Cherwell District Council: Begbroke Science Park, Begbroke Hill, Begbroke, Kidlington, OX5 1PF

On behalf of our client, Oxford University Development Ltd (OUD), please find enclosed an application for a Non-Material Amendment (NMA) to full planning application (Ref. 21/03195/F) (dated 4 February 2022) for:

“Formation of surface car park and service building (including substation, sprinkler tanks and EV charging infrastructure)”.

PAVEMENTS PLAN

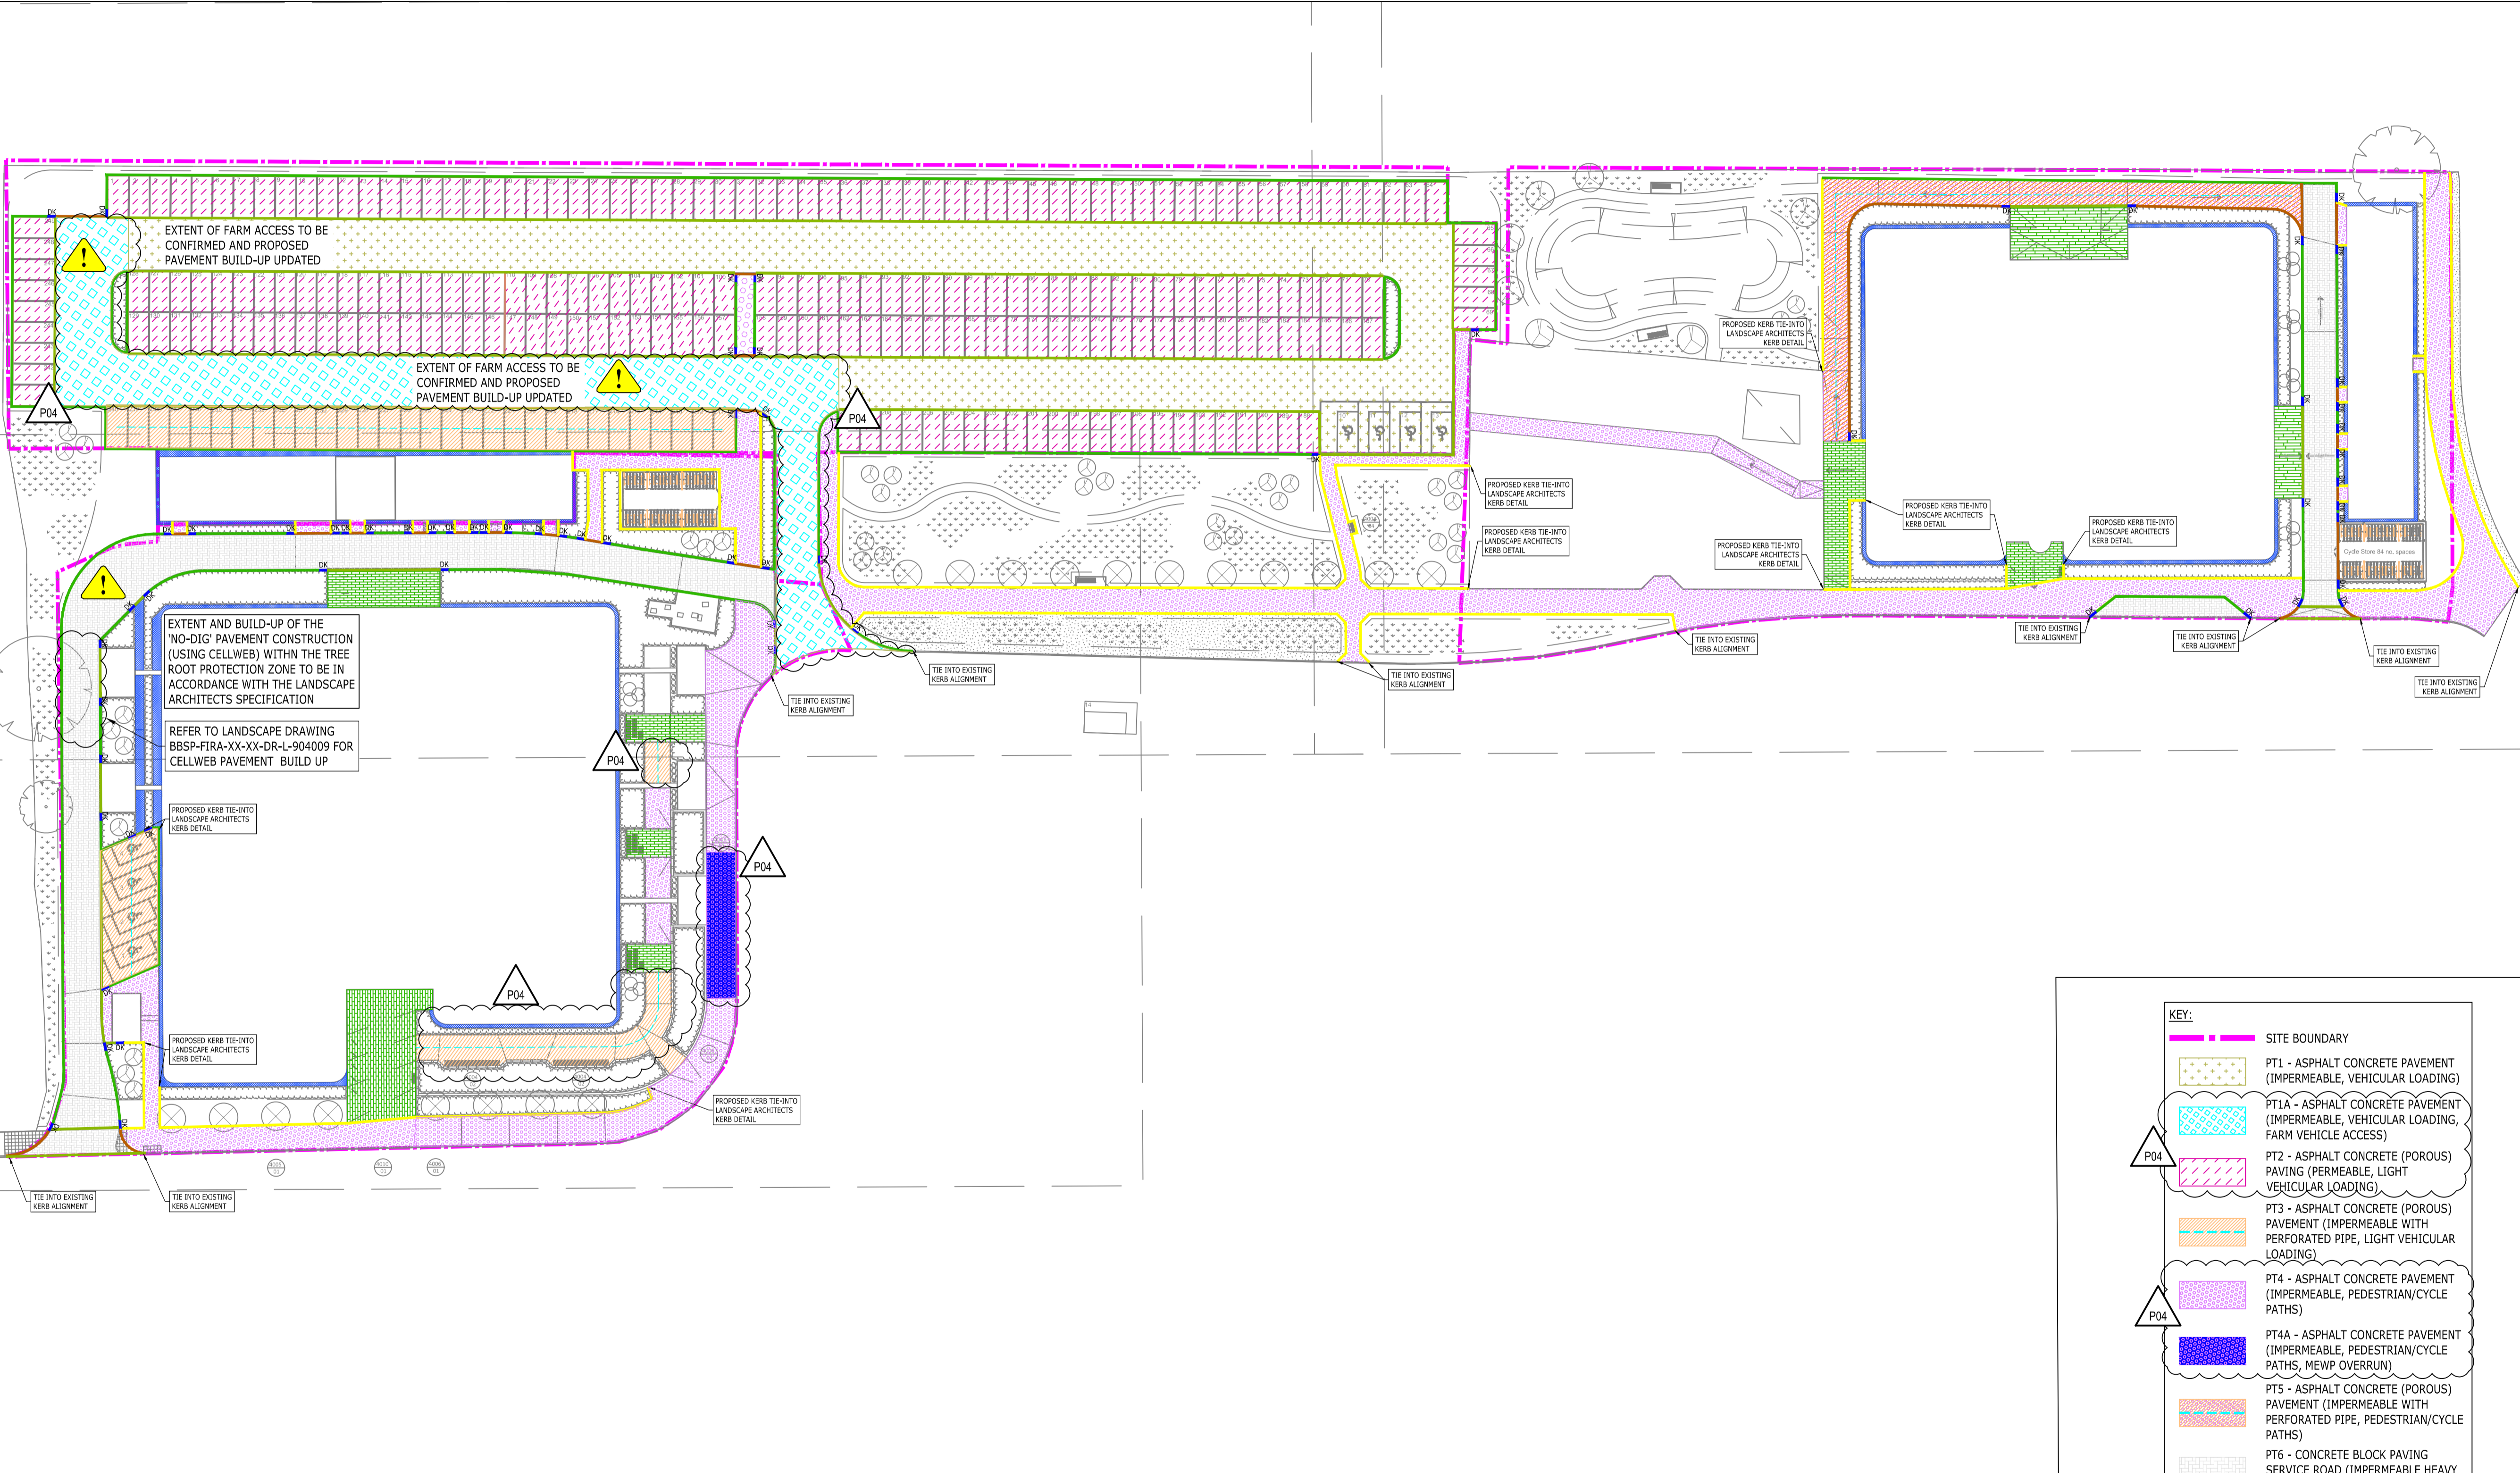
“The porous block paving previously proposed for the parking bays in the surface car park was replaced with a porous asphalt material in the current design proposal. The proposed pavement build-up in the surface car park aisles are unchanged and comprises an impermeable asphalt concrete pavement build-up.

The car parking bays include a porous/permeable pavement build-up with a sub-base drainage layer made up of coarse graded material. The permeable pavement build-up in the parking bays allow for surface water infiltration to ground, however, for the parking bays nearest the ancillary buildings (to the north of the Commercial Building) the sub-base drainage layer is used to attenuate surface water run-off which is carried in a perforated pipe (in the sub-base layer) to the soakaway tank.

drawing title:
Car Park
Landscape General Arrangement

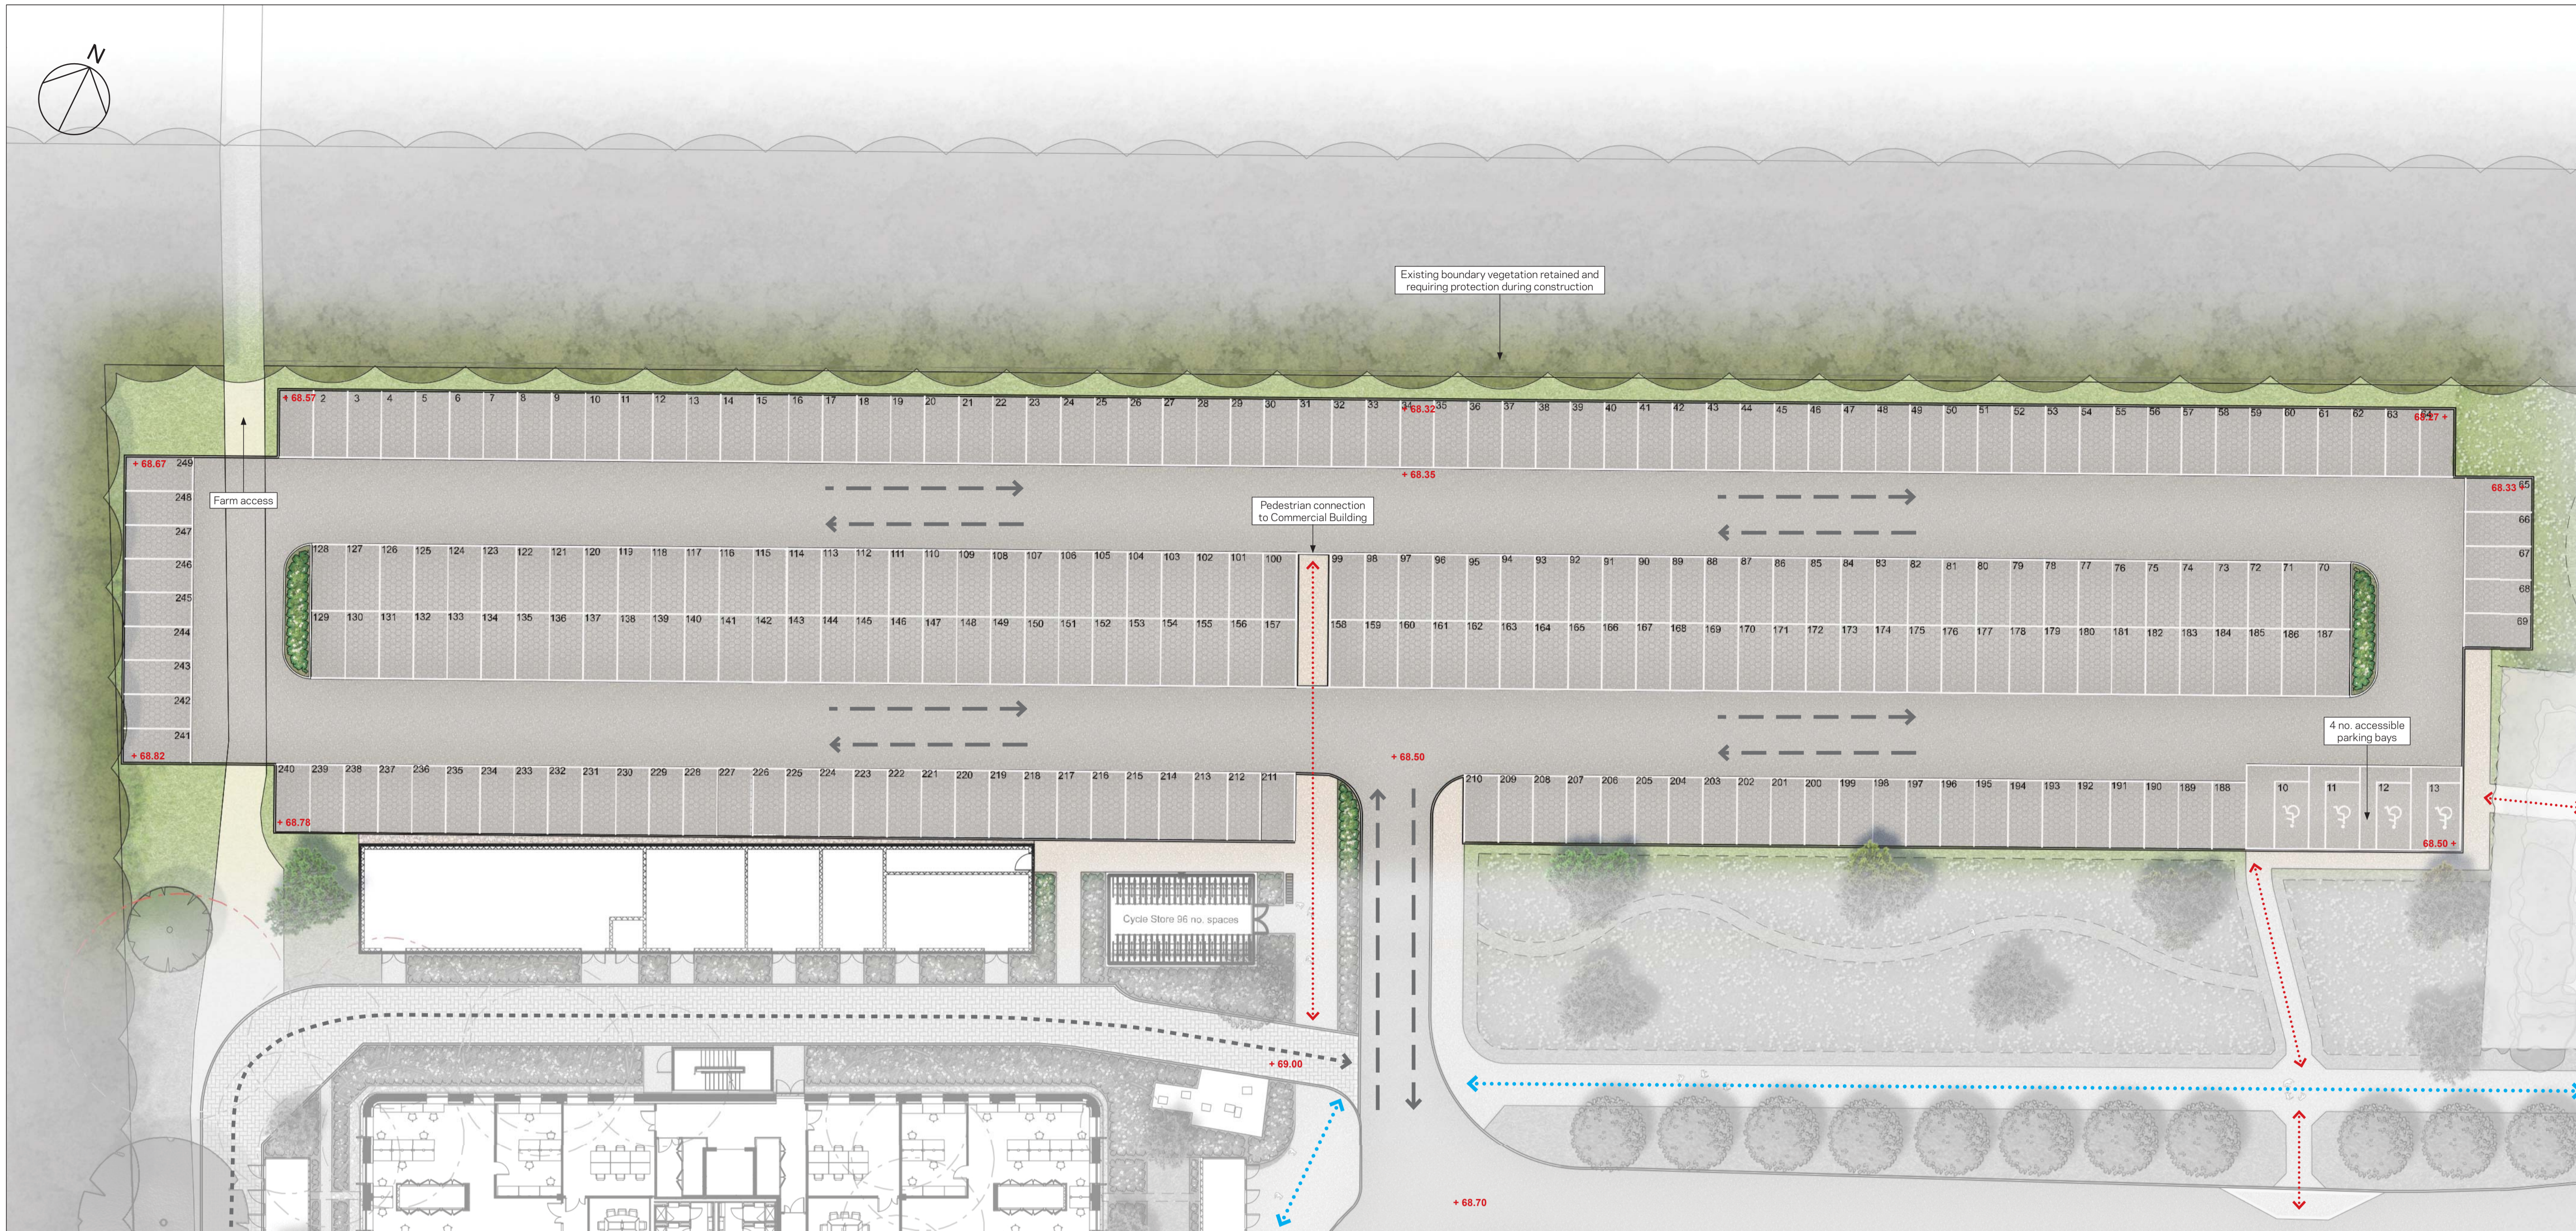
As OUD has progressed with the detailed design of approved application 21/03195/F it has become apparent that there is a need to change the permeable block paving to parking bay surfacing with a porous bituminous macadam surface.

The Non-Material Amendment proposes the substitution of permeable block paving to parking bay surfacing with a porous bituminous macadam surface. This design change is in response to design and technical constraints which have become apparent during the design stages following the planning submission. There have been frequent failures using permeable block paving which also has high maintenance requirements therefore porous bituminous macadam surface is considered a more appropriate solution.
